Development Control  
Ribble Valley Borough Council

**Re:** Planning Application 18/0992

**Address:** New Fold Garage Neville Street Longridge PR3 3FD

**Description:** Proposed additional valeting service to an existing garage operation and erection of 1.7m high Perspex panel screen.

**Drawing Title :-**  
 Existing & Proposed Front (South) Elevation

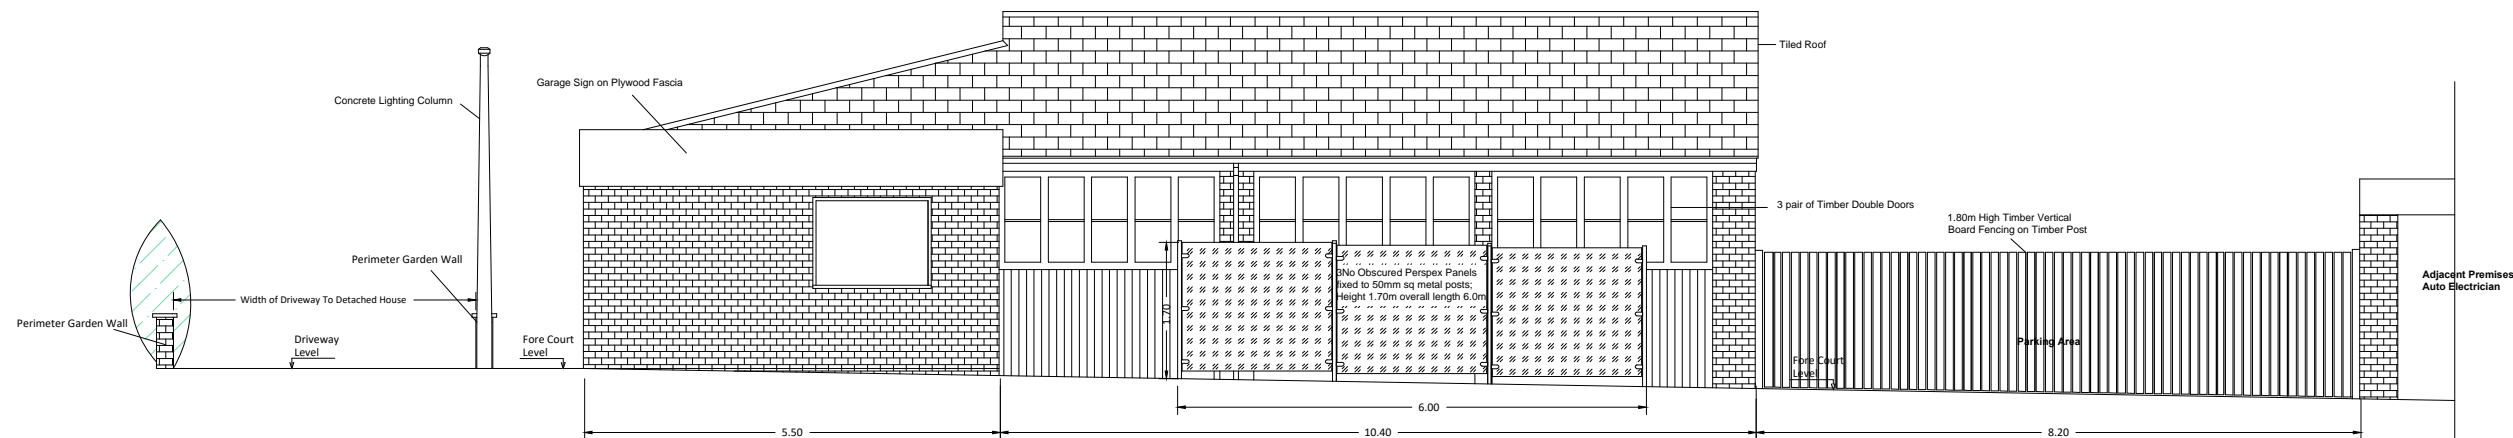
There is a discrepancy between the description of the proposal on the application form and the information supplied on the latest drawings supplied. The application makes reference to the valeting being an additional service to the existing garage, and known internet car sales services.

**BLOCK PLAN**  
 1:500

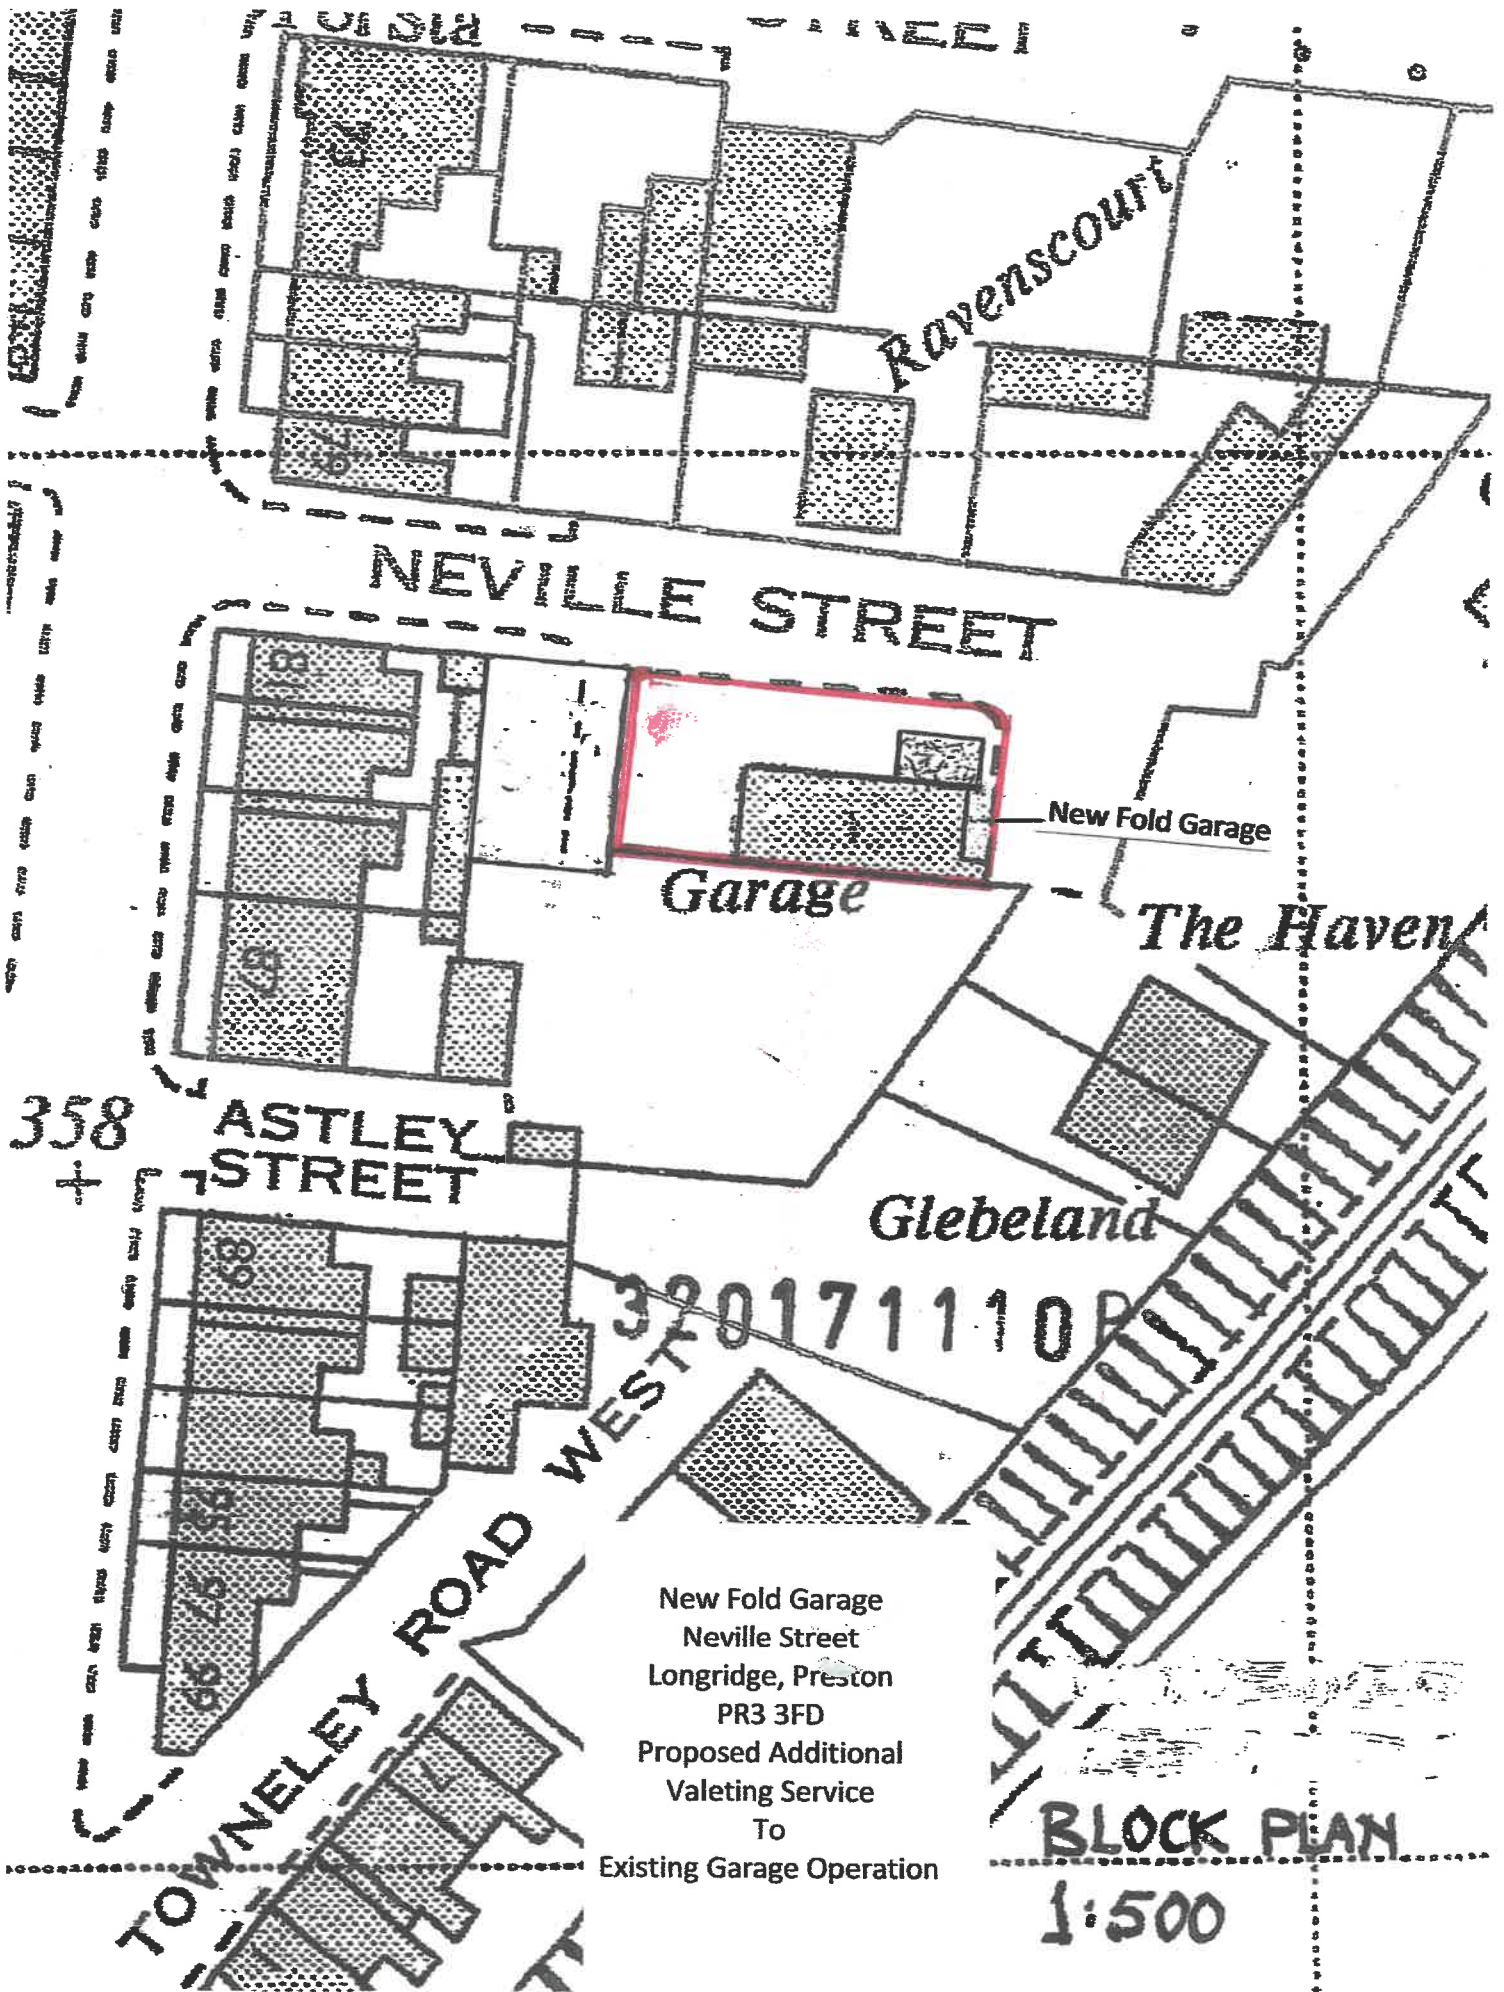
It is noted that any vehicles waiting to be washed are expected to wait on the highway opposite the residential premises, or outside the adjacent commercial premises. The onsite parking is likely to be taken up by drivers dropping off cars for pre booked valets they are likely to simply park and leave the vehicle potentially entering through the queue rather than waiting.
